PROJECT TITLE Harrington Four Plex

TYPE OF SUBMITTAL Grading Plan
(revised)

February 1, 1983

Re: Narrington Fourplex - 1721 Paisano
✓ (J22-D26)

J22/D26

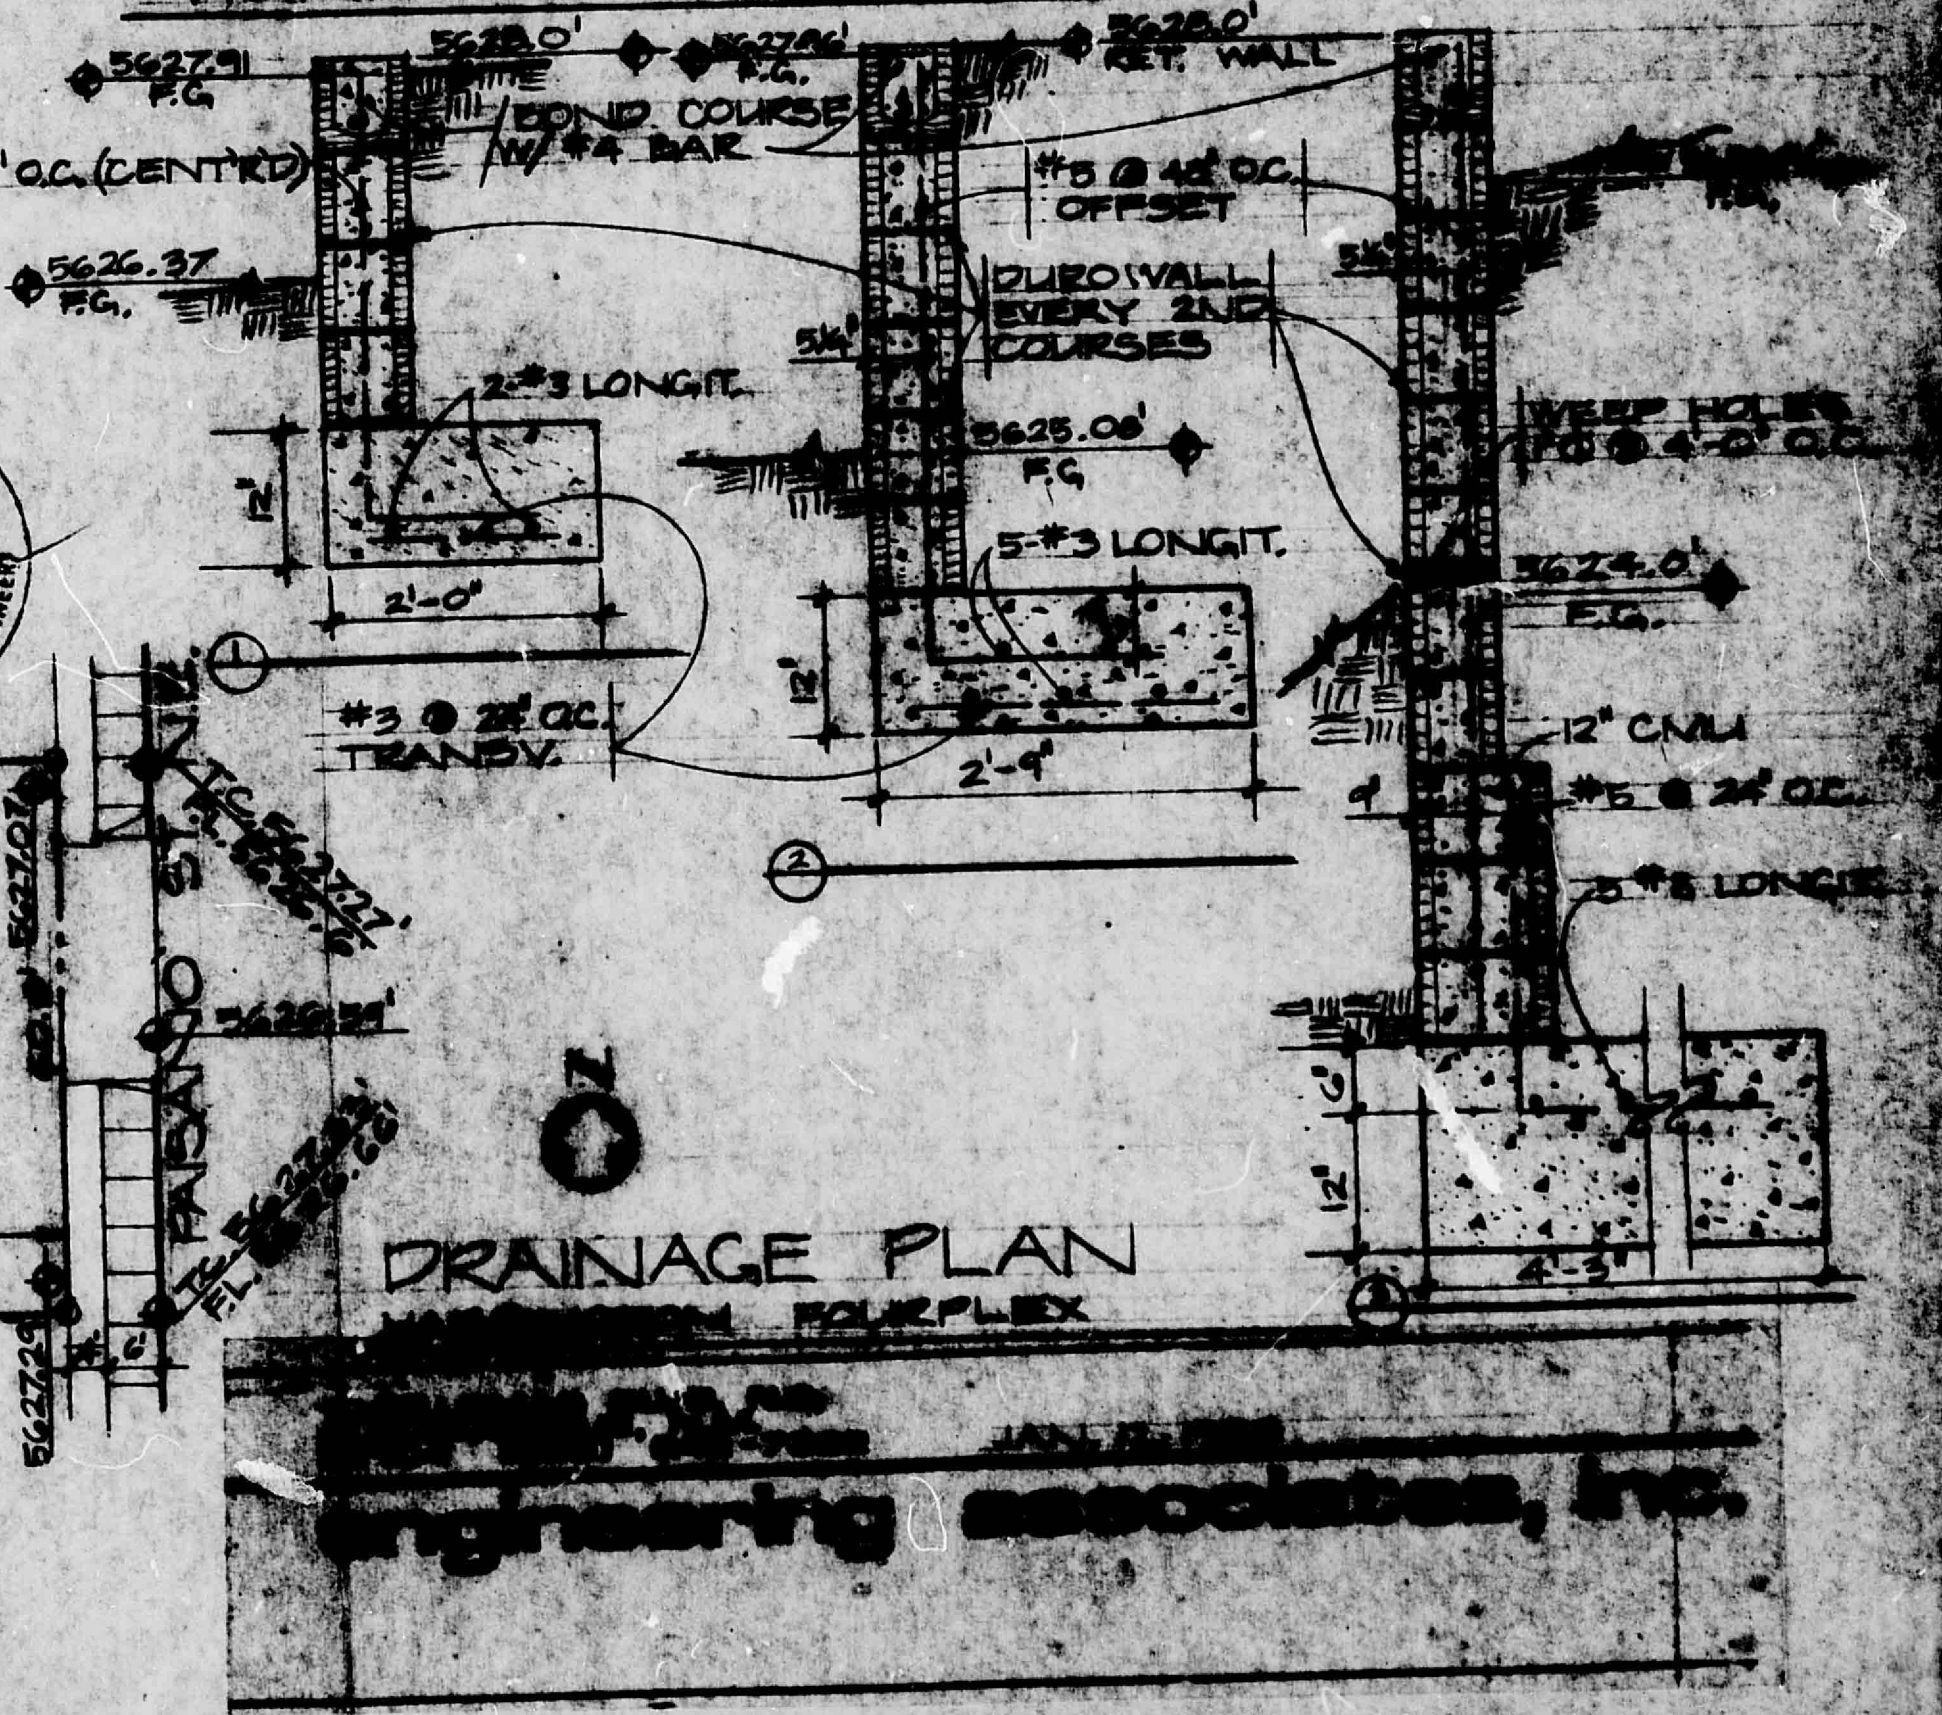
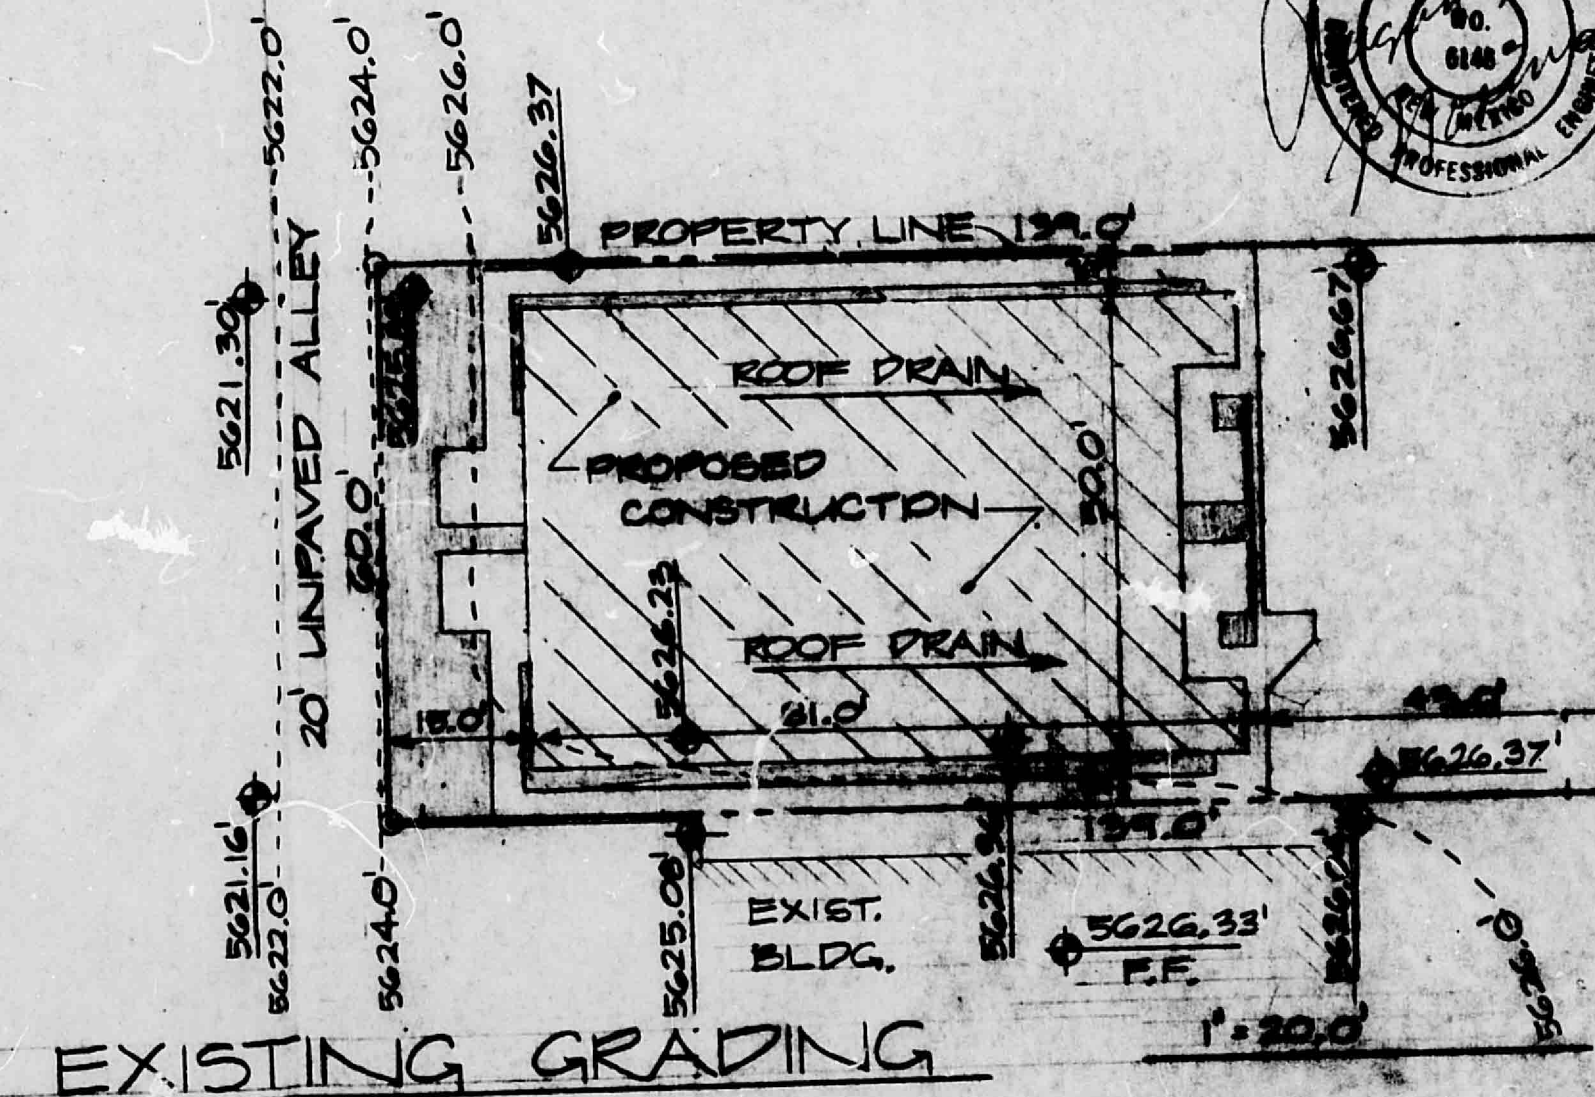
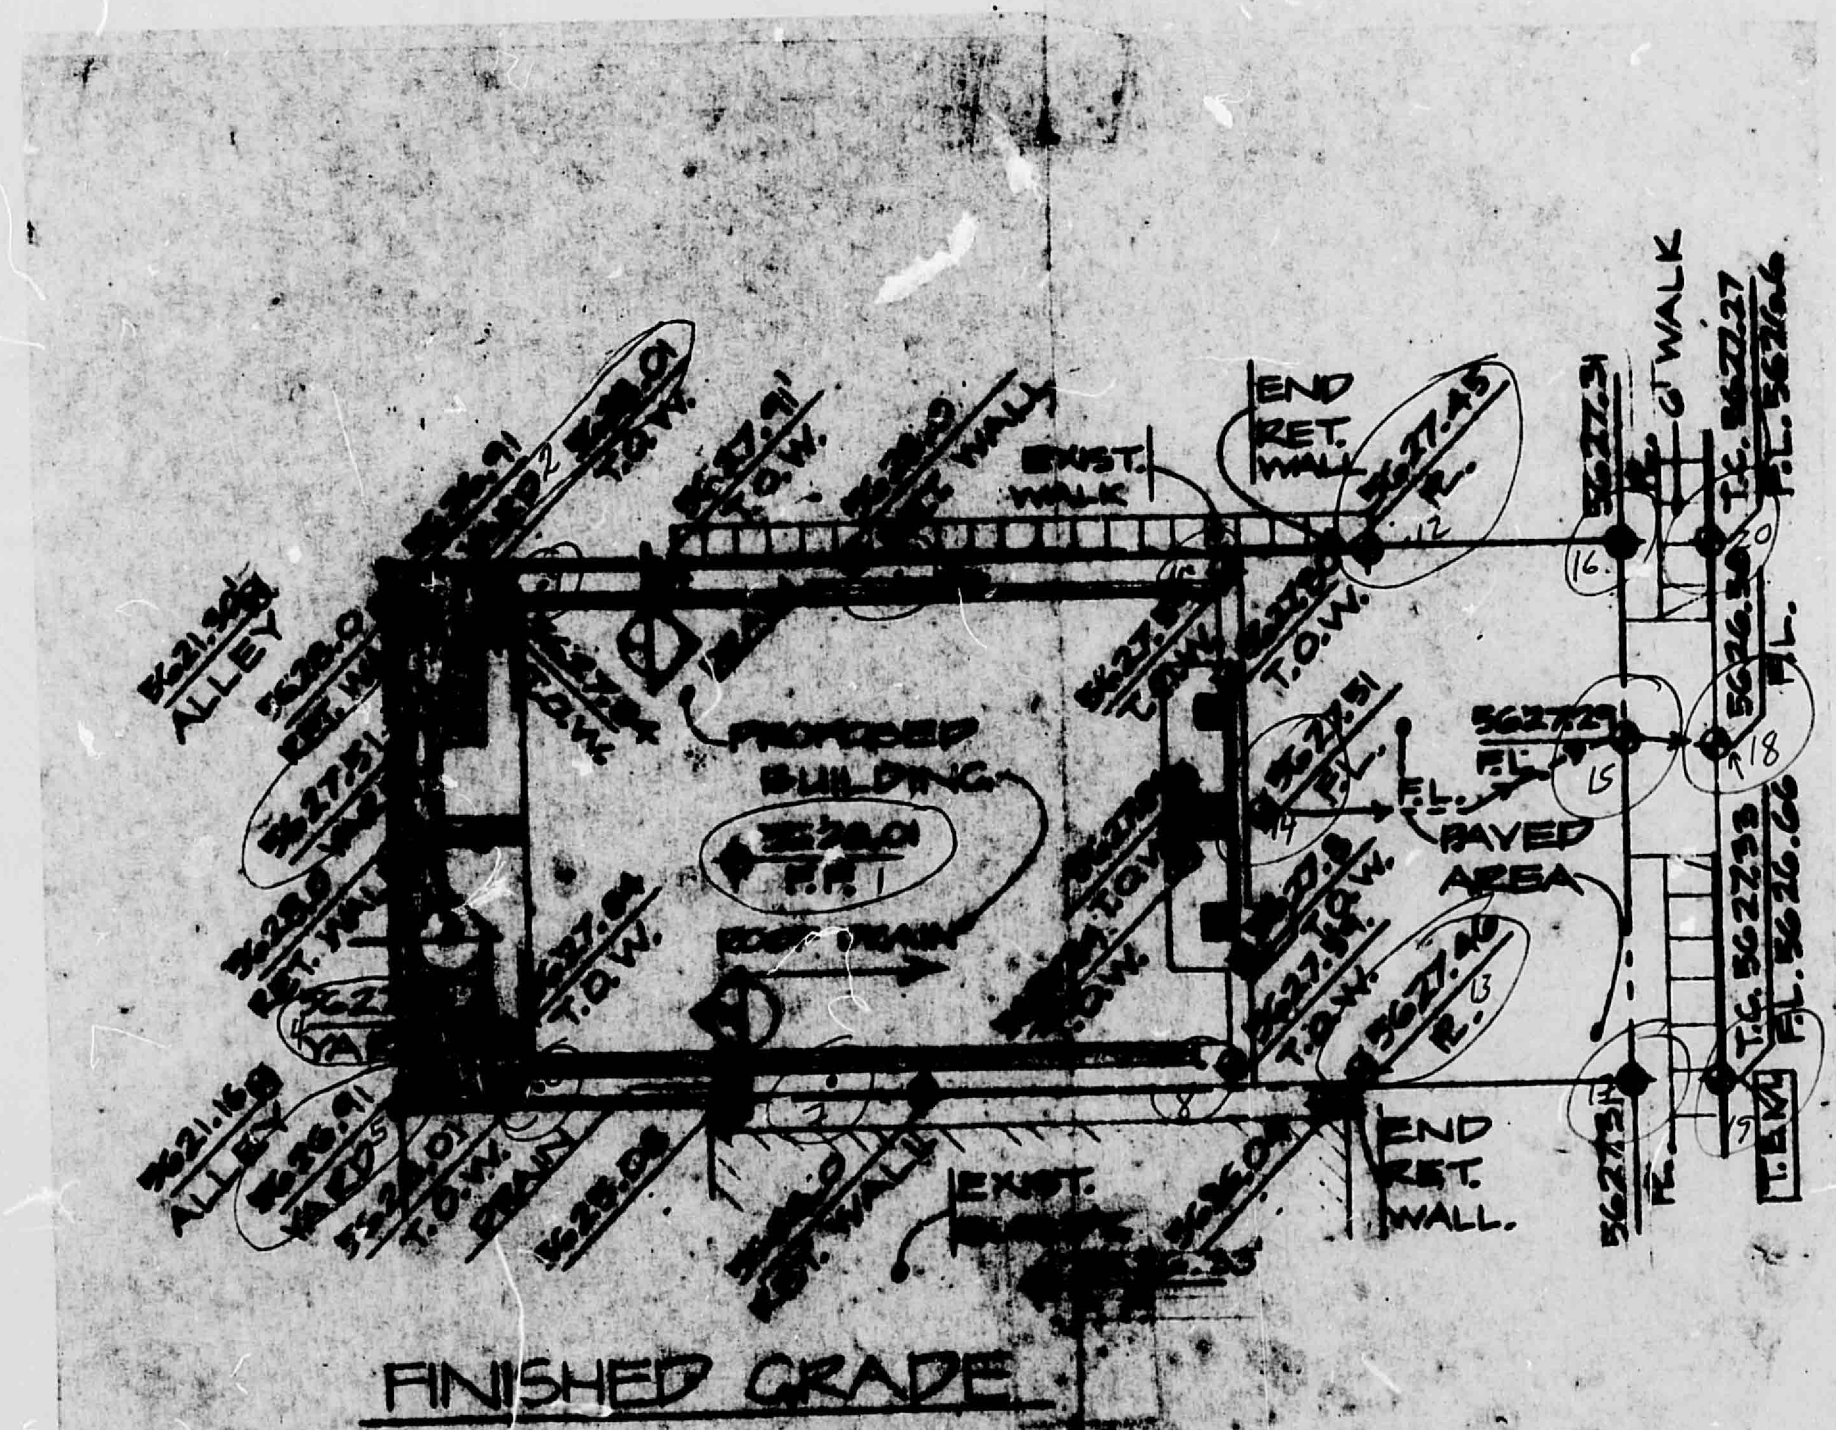
The drainage plan referenced above cannot be reviewed without the inclusion of the information below with your drainage plan. Provide this information with your resubmittal so that we can continue the review of the drainage plan.

1. City approved alley grades.
2. Sufficient grades supporting the proposed scheme to discharge the developed runoff to the City's right-of-way.
3. More flowline elevations within Paisano to determine the direction of flow.
4. Driveway elevations.
5. A comprehensive grading plan with the existing grades superimposed with the proposed elevations.

To the site plan we have incorporated the following changes

1. The finished floor elevation of the existing building to the south has been added.
2. The retaining wall section at the back property line has been revised to show that no new grading is taking place in the alley.
3. The property lines have been designated.
4. The developed site plan has been re-drawn to the proper scale.
5. A temporary bench mark has been indicated.

Also enclosed is a copy of the plan and profile sheet for Paisano Street. It indicates that flow past the site is northerly toward Indian School Rd. This development therefore will not worsen the flood hazard area at Lomas and Juan Tabo, which is south of the site.
